Our ref: B/25/0225

**Re: EN 010151 - Beacon Fen Energy Park**

**Boston Borough Council's - Deadline Two Submission - 21<sup>st</sup> October 2025.**

DS

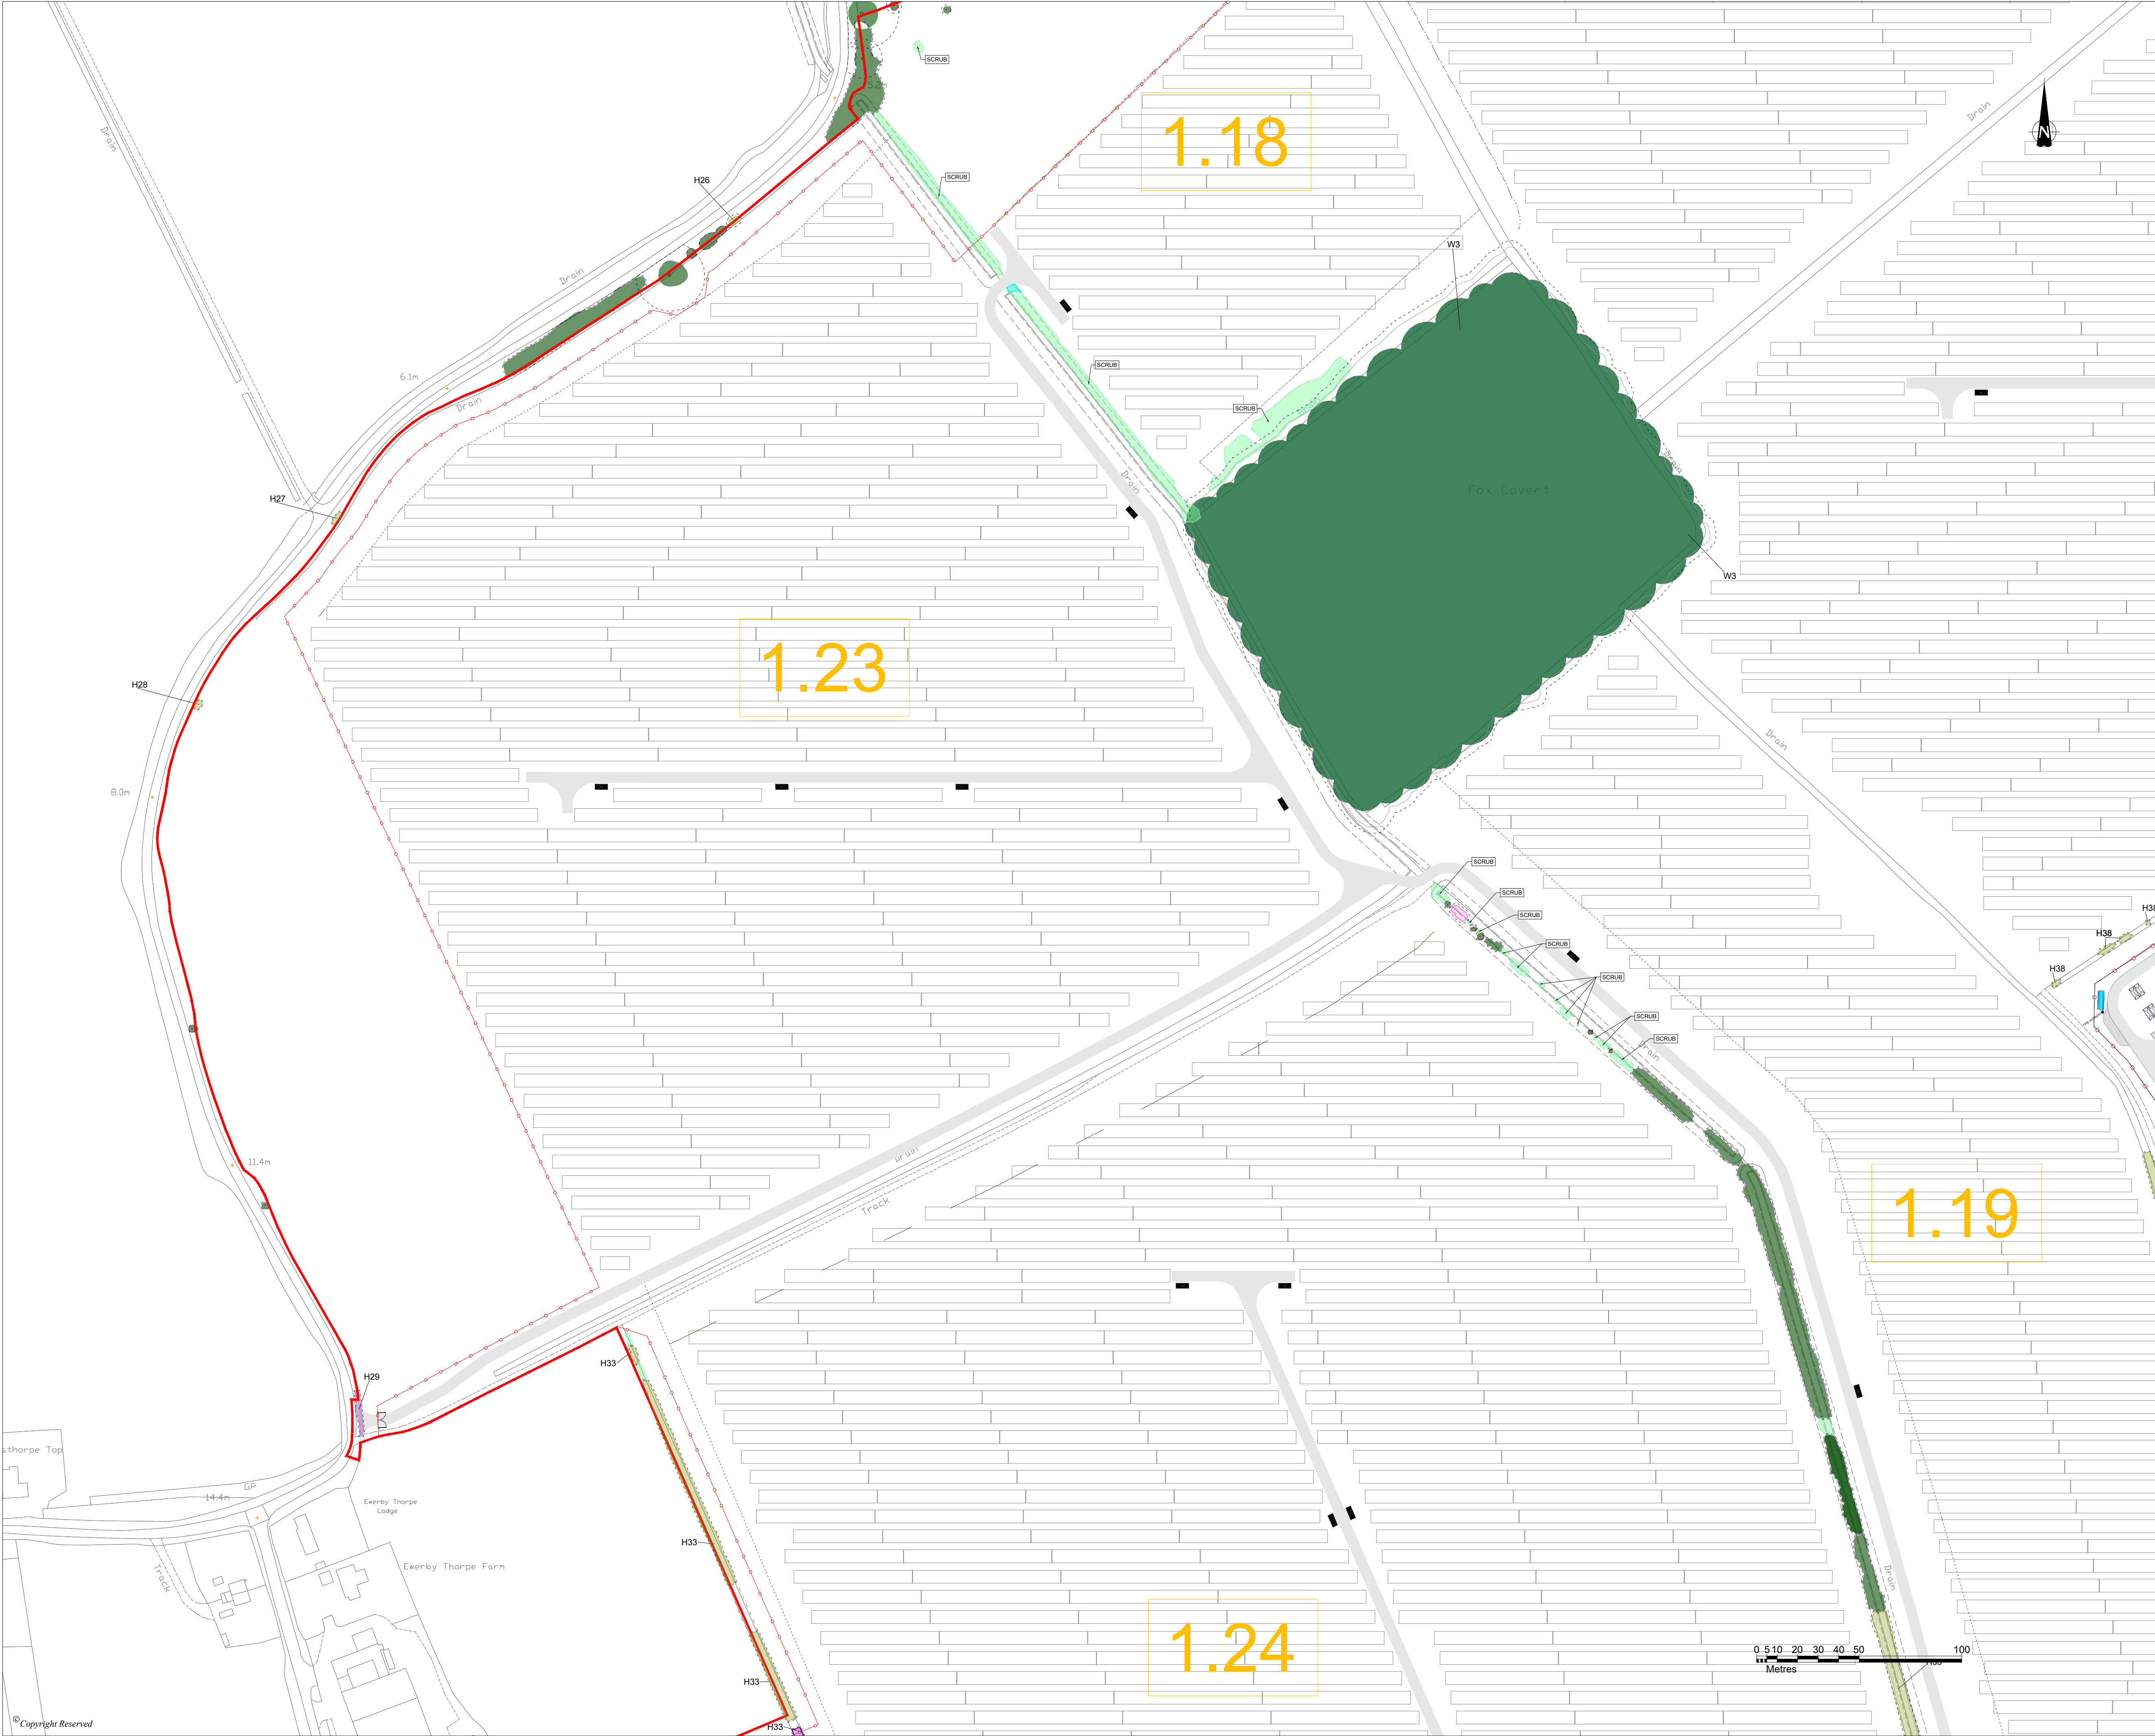
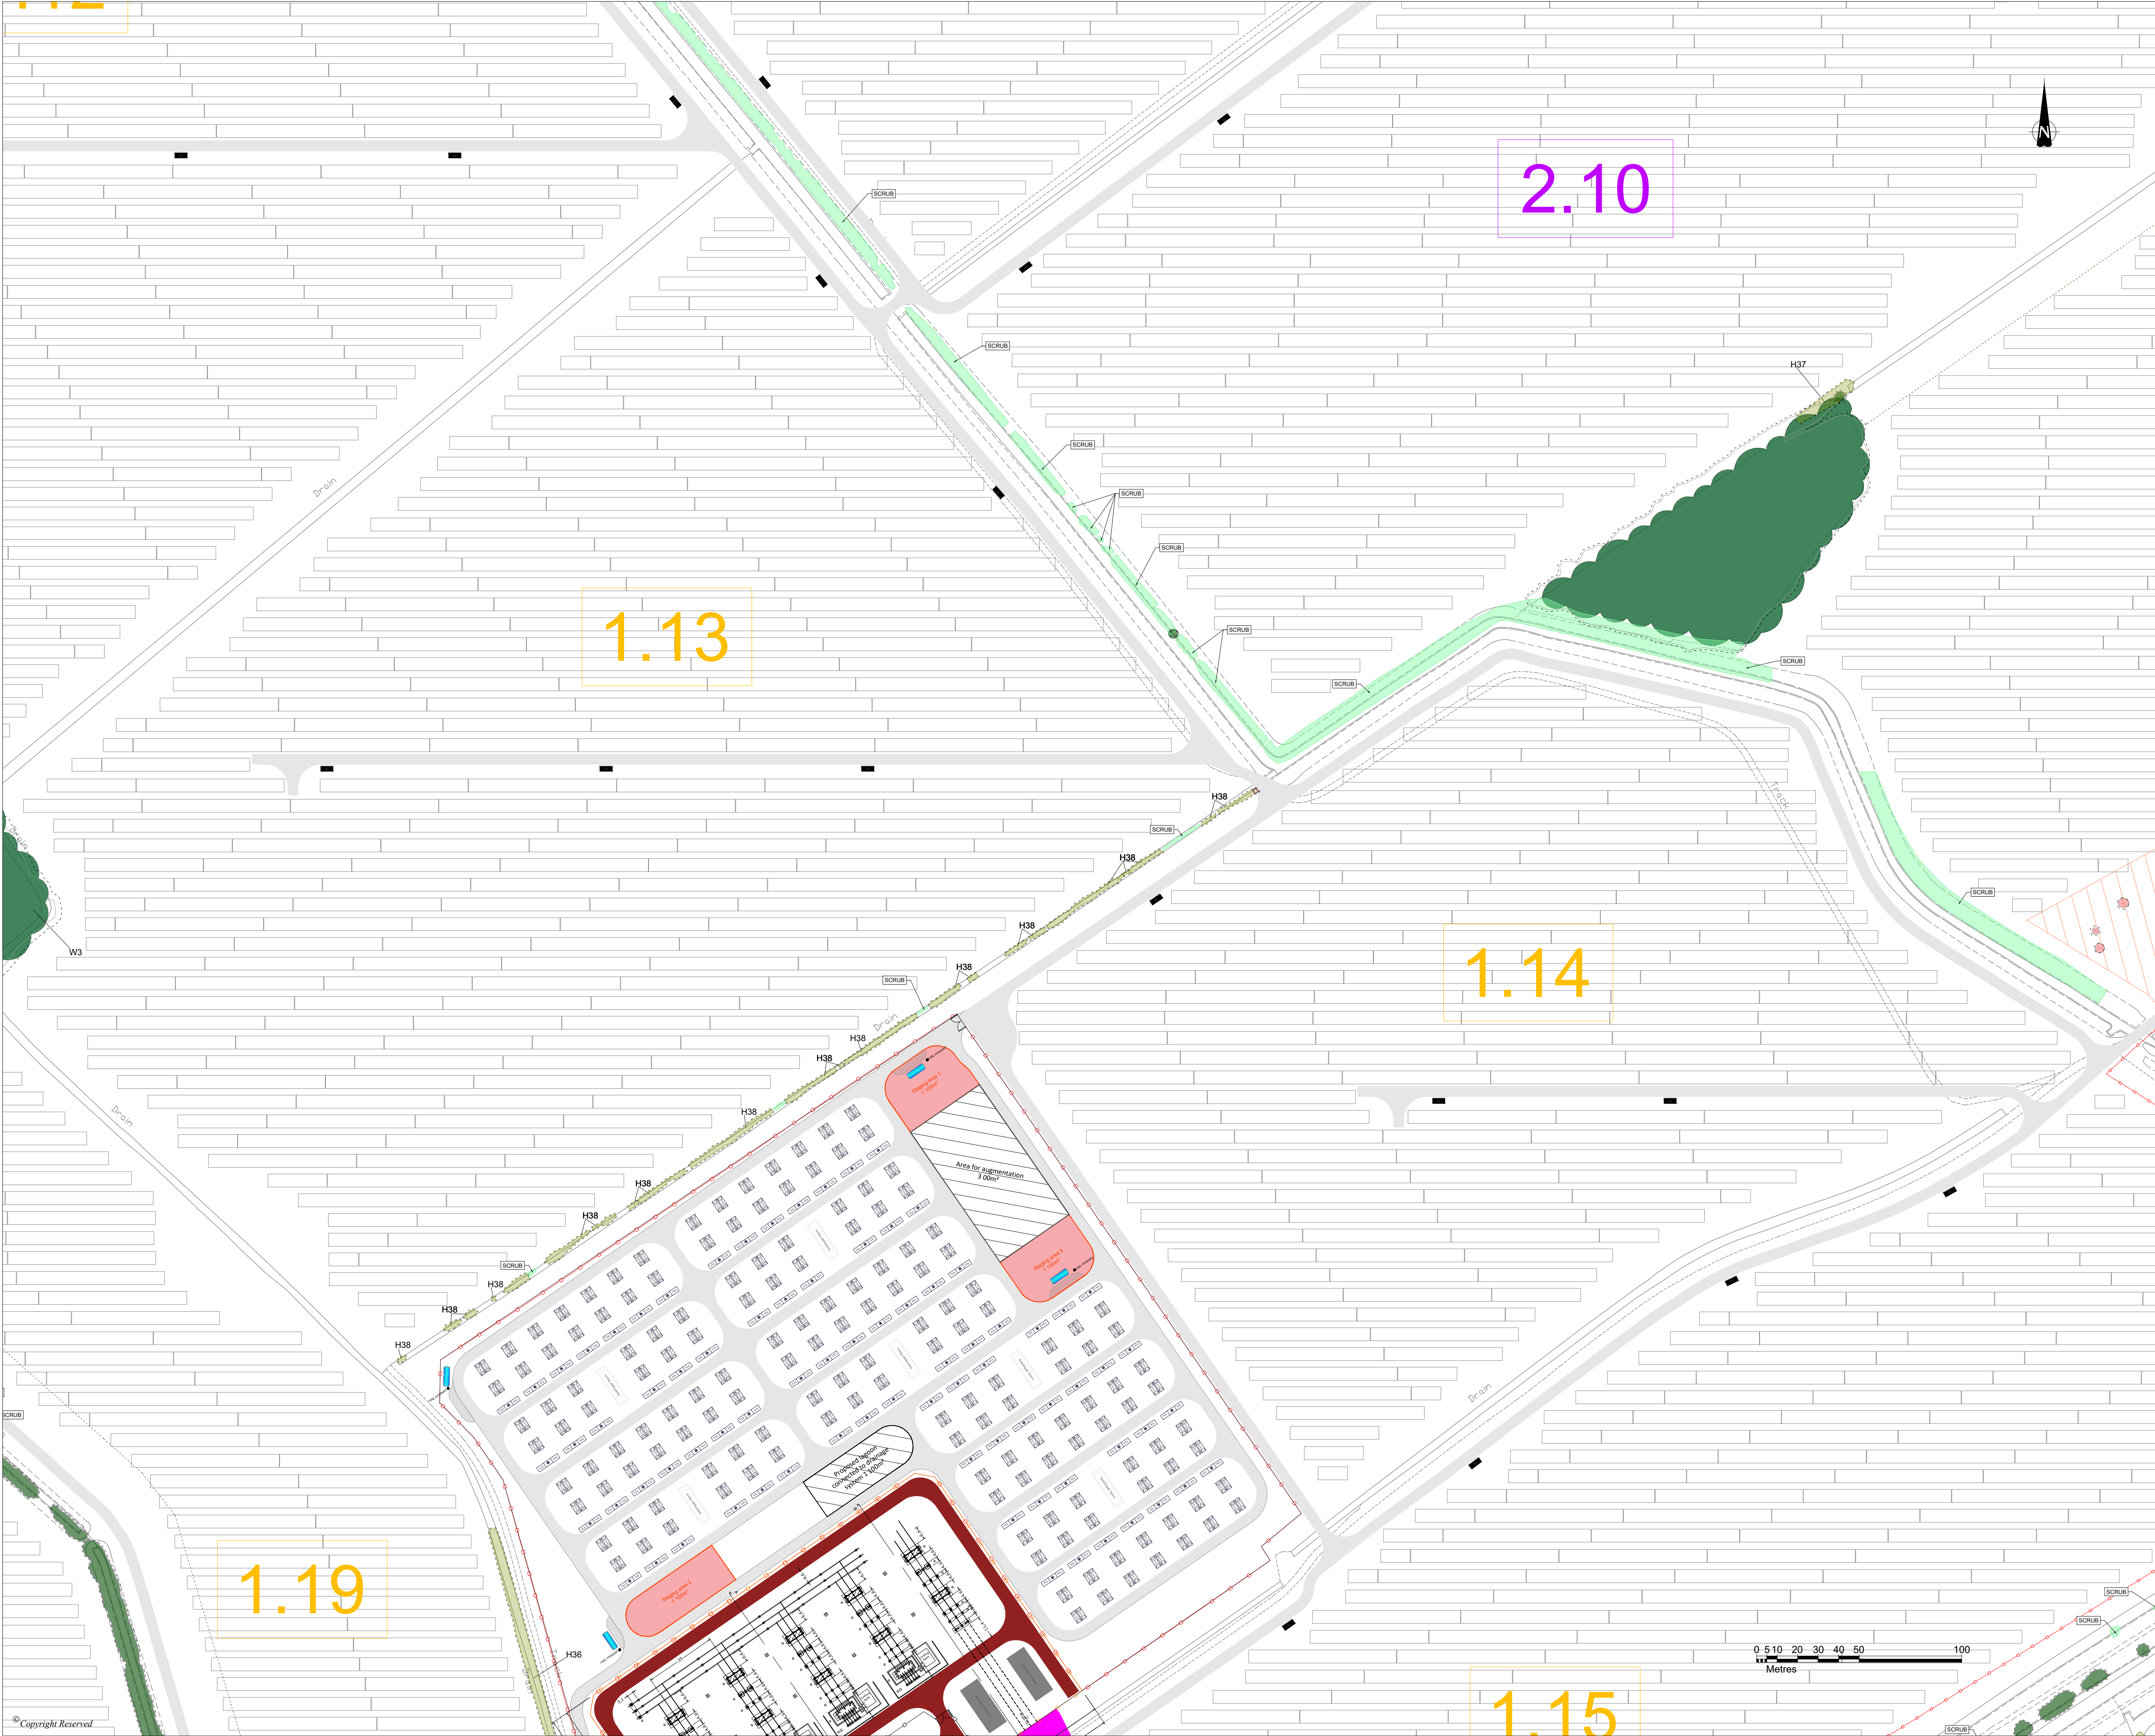
BBC welcomes the Applicant's update to Figure 6.32 Vegetation Removal Plan (REP1-015) that provides the following clarification;

- that there will be no requirement to remove existing vegetation within the South Forty Foot Drain; and
- of the extent of potential vegetation removal and retention at Bicker Fen Substation.

BBC seeks further clarity on how the vegetation shown as retained on the updated Vegetation Removal Plan and the Vegetation to be removed are secured within the Requirements of the draft DCO.

BBC wishes to ensure that vegetation shown as retained on the updated Vegetation Removal Plan and the Vegetation to be removed are secured and approved by the relevant Planning Authority within the Requirements of the draft DCO.

As noted above the Applicants update to the Vegetation Removal Plan is welcomed and provides the necessary clarity at this location provided that vegetation shown as retained on the updated Vegetation Removal Plan are adequately secured and that they will be approved by the relevant Planning Authority within the Requirements of the draft DCO.
